DECISION DELEGATED TO HEAD OF PLANNING**DECISION DELEGATED TO HEAD OF PLANNING**

Application No: H06-0969-24 **Applicant:** Ms C Bushby

Proposal: Use of land to provide thirteen additional gypsy/traveller pitches with internal access road and landscaping

Location: Green Acres Park Ropers Gate Gedney

SCALE: 1/500 DATE: October 2018 DWG No. 1967/1

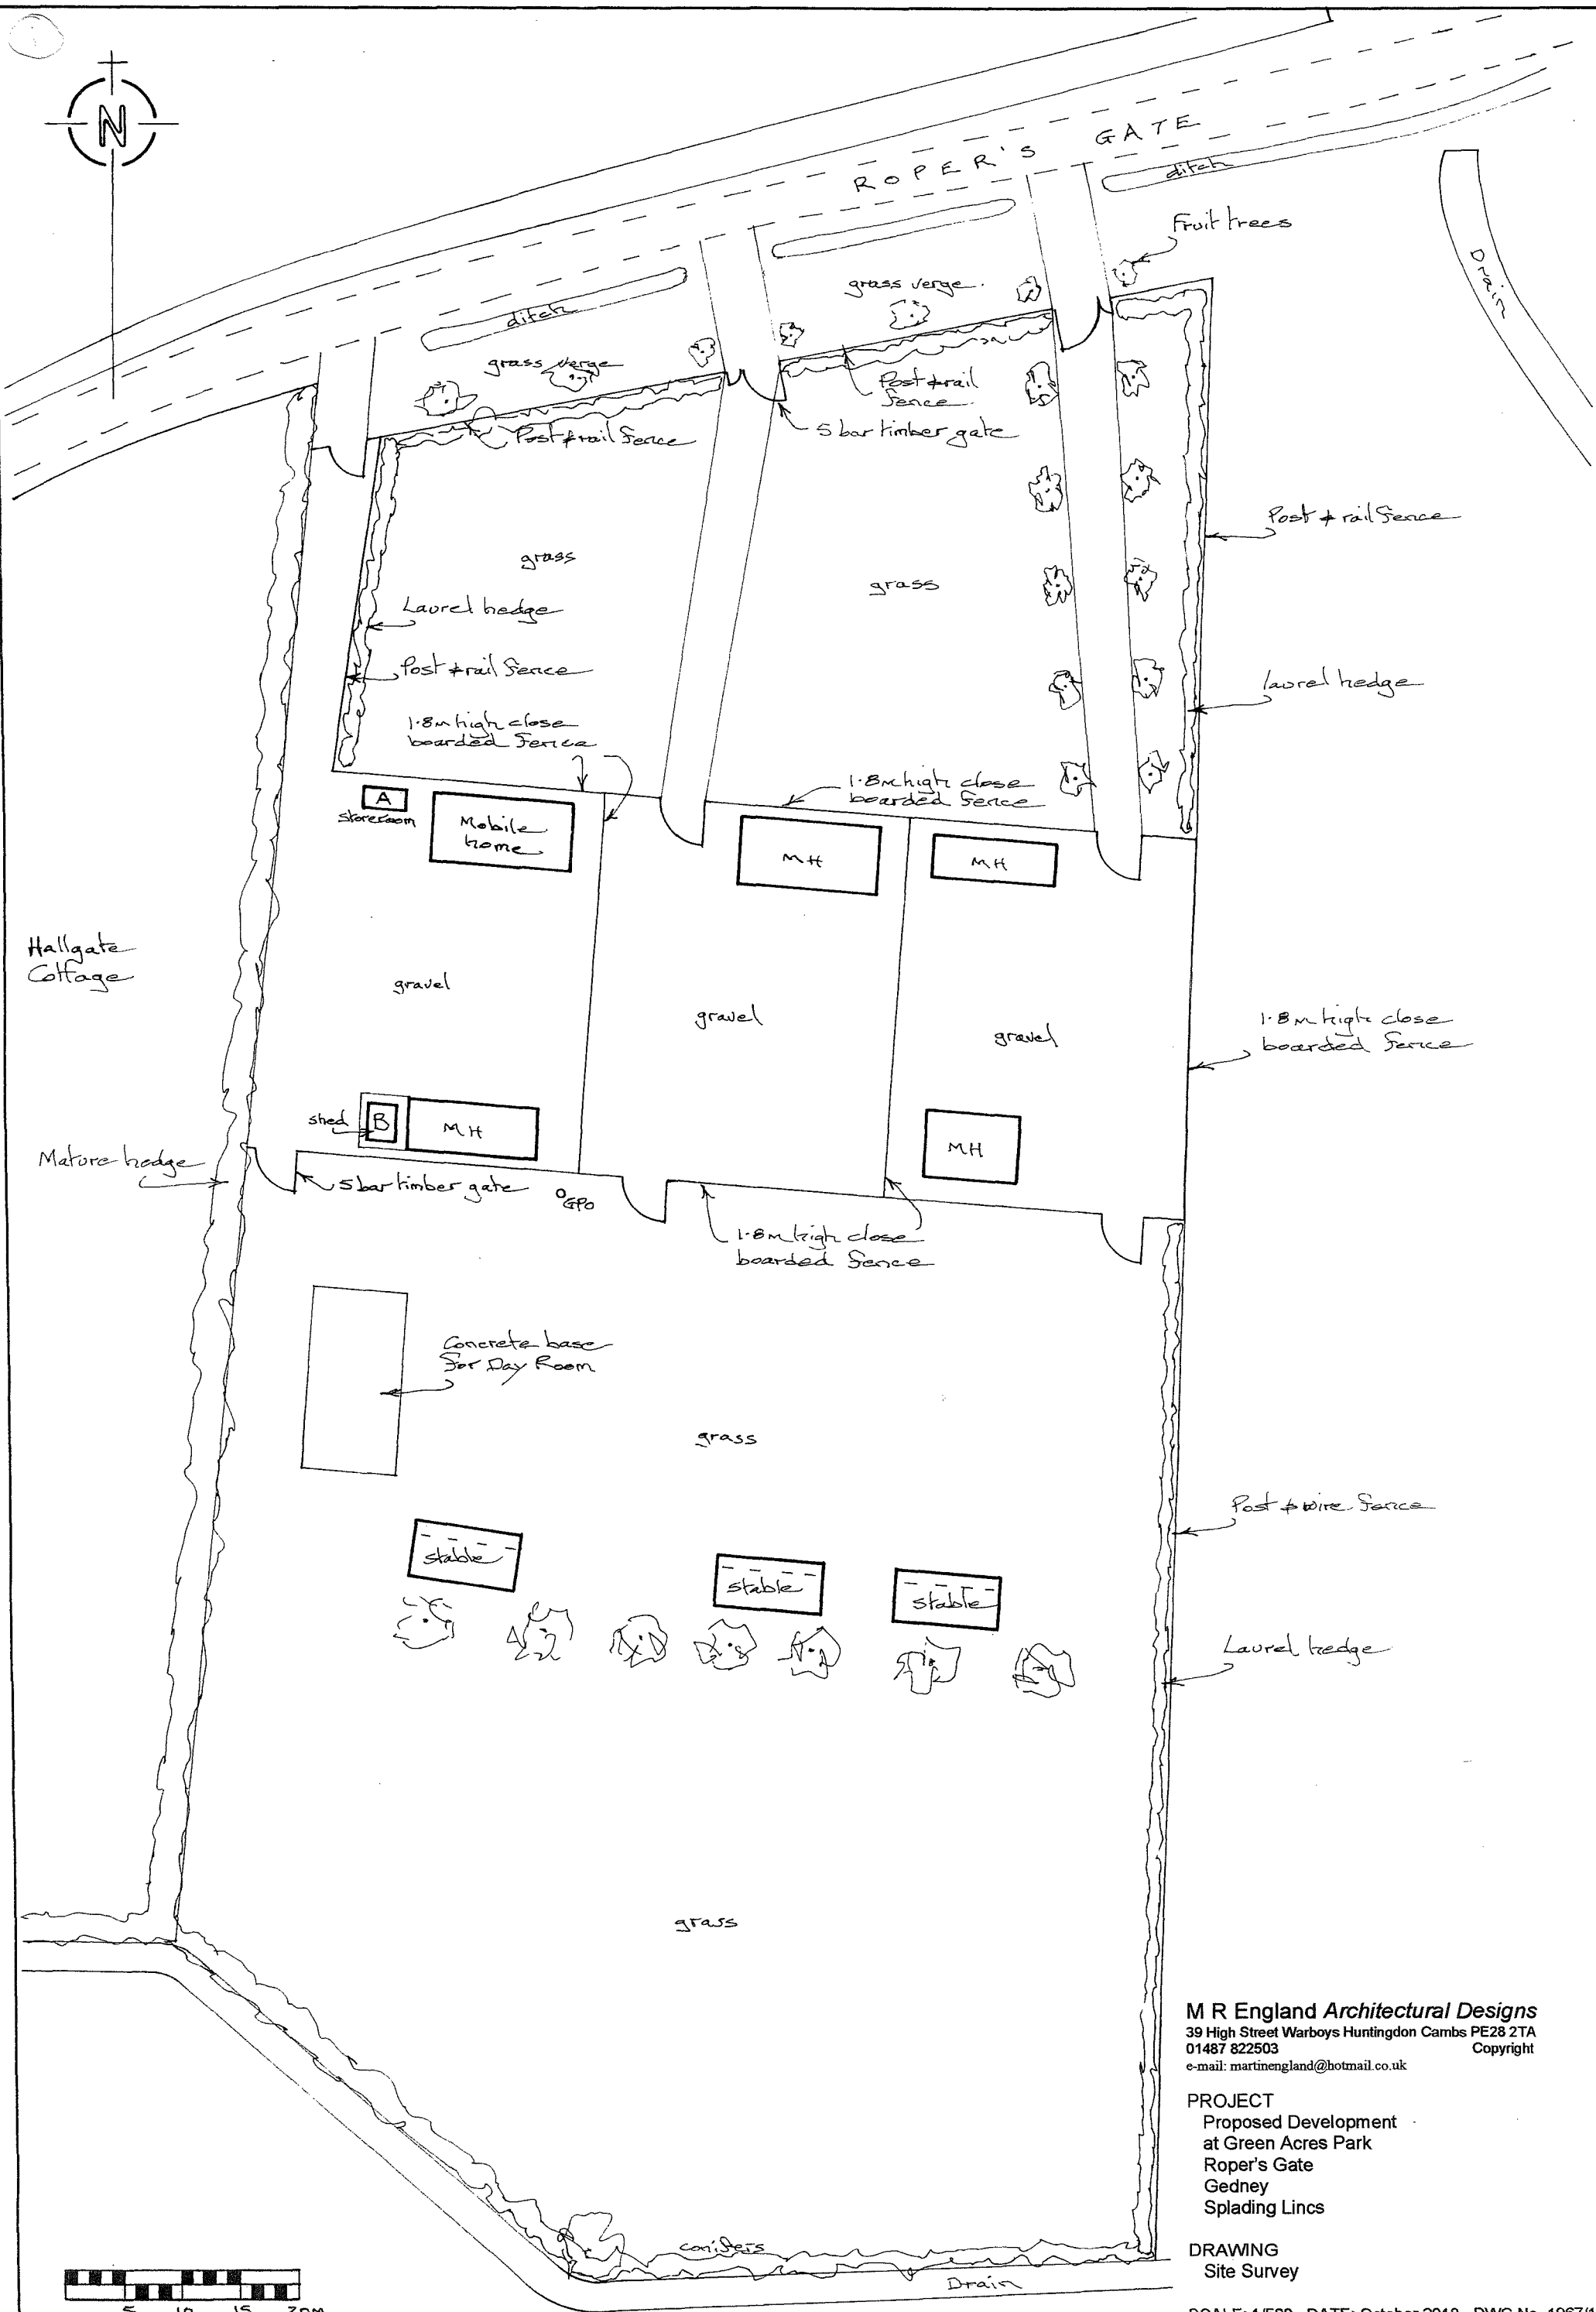
Whilst the approach is the same with regards the ecological related documents, there appears to be some conflict with the proposed site plan which shows plots 1 and 16 to be in the area given over to BNG. This would need addressing.
